**Your Ref:** OWPC19556  
**Our Ref:** FG/116/18/HH 08-06-2018  
**Please ask for:**  
Amber Willard

Loft conversion  
2 Ocean Drive Ferring

Thank you for your internet representation made on 8th August 2018 which has been recorded as '**an objection**' with the comments as follows:

PROPOSED SOUTH WEST ELEVATION

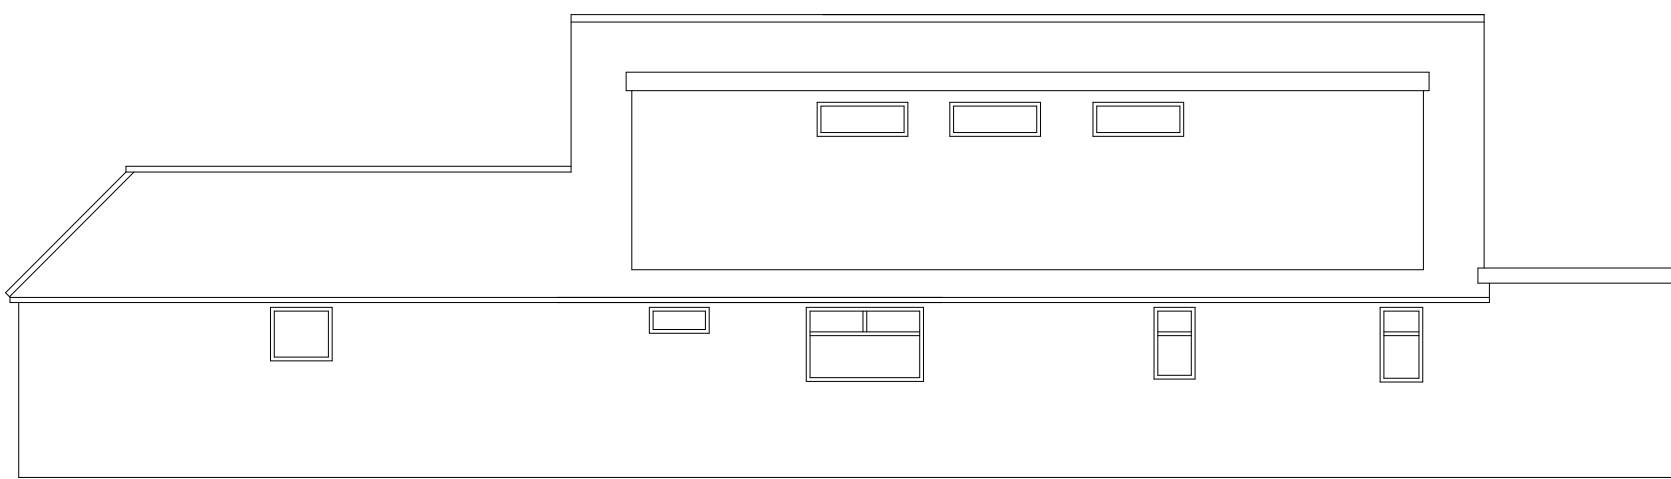
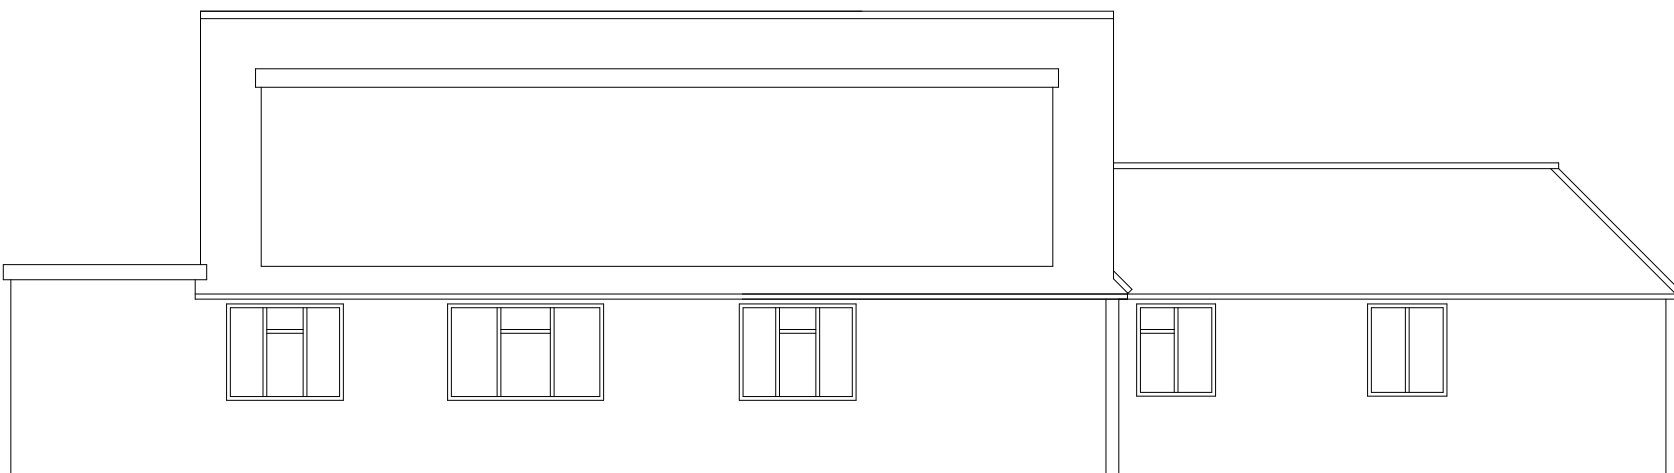
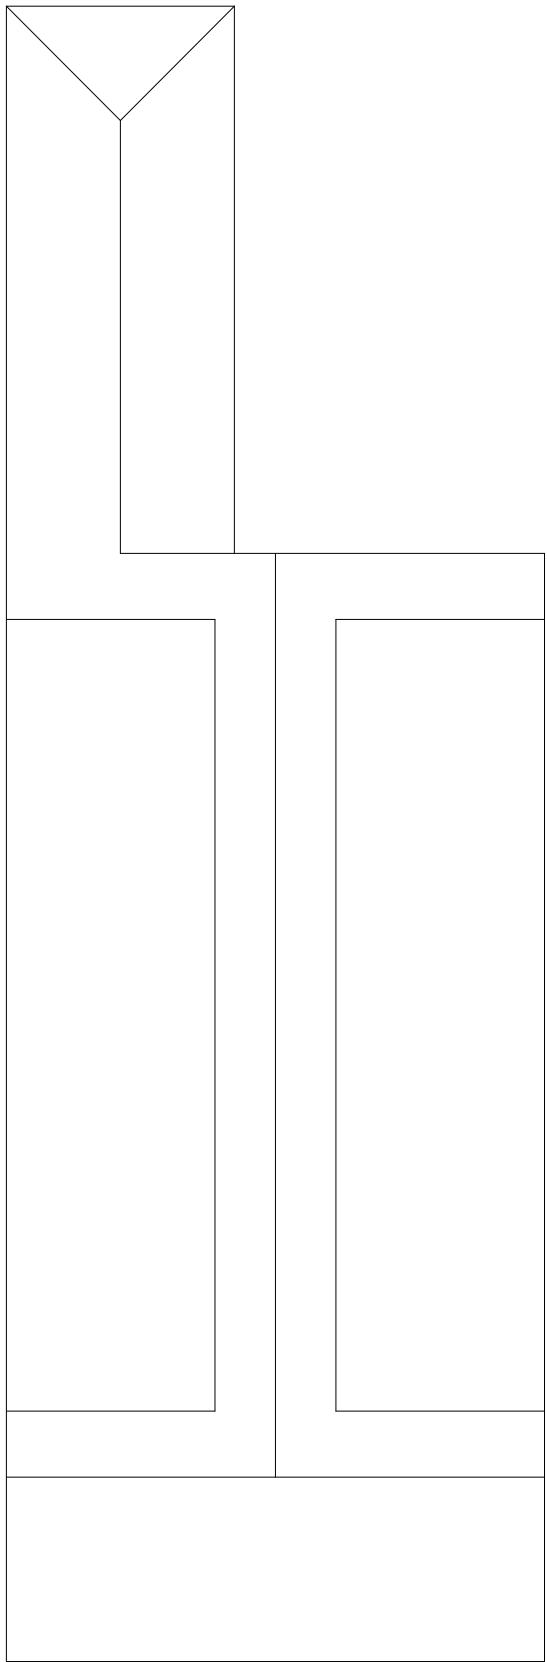
*The application appears to effectively be a change from a pretty bungalow to a 2 storey dwelling with its oversize box dormer addition which will considerably overshadow its neighbouring bungalows.*

*The overall design of this proposal has been made with little concern for planning style, is out of keeping with adjacent bungalows and will visually impact on the street presentation of the local area.*
